ENVIRONMENT PROTECTION AUTHORITY

### Homebush Bay Bridge (MP10\_0192) Environmental Assessment review

### **Detailed comments on the Homebush Bay Bridge (MP10\_0192) Environmental Assessment**

Figure 12.1 – Berthing locations in the Homebush Bay area

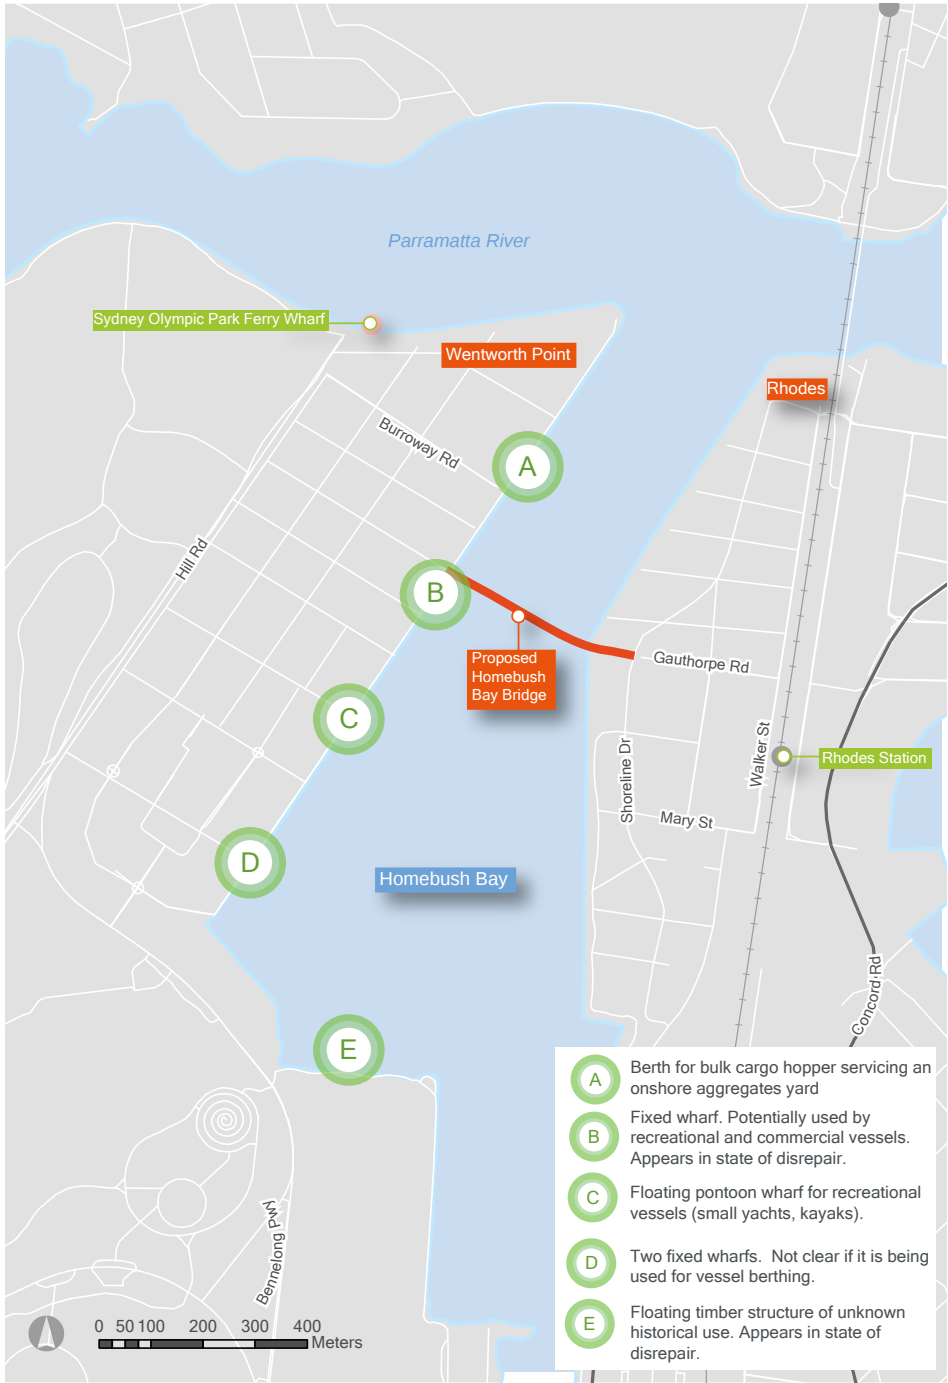
Figure 2.1 shows a wharf on the western side of the Bay upstream of the Bridge that is either new or scheduled for redevelopment. Figure 12.1 also shows a range of wharves and pontoons in the Bay. Any development that would facilitate increased boating activity within such a heavily contaminated part of the Harbour that could add to the mobilisation of the highly contaminated sediments within the Bay is considered counterproductive by the EPA. It would have the potential to prolong the impact of contaminants such as dioxins on the body of Sydney Harbour.

- A floating timber structure of an unknown historical use located at the southern end of the bay near Bennelong Avenue ('E' on Figure 12.1). This structure is in disrepair and unlikely to be functional;
- Two fixed timber wharves/jetties ('B' and 'D' on Figure 12.1); and
- One floating pontoon wharf ('C' on Figure 12.1) south of the proposed bridge alignment.
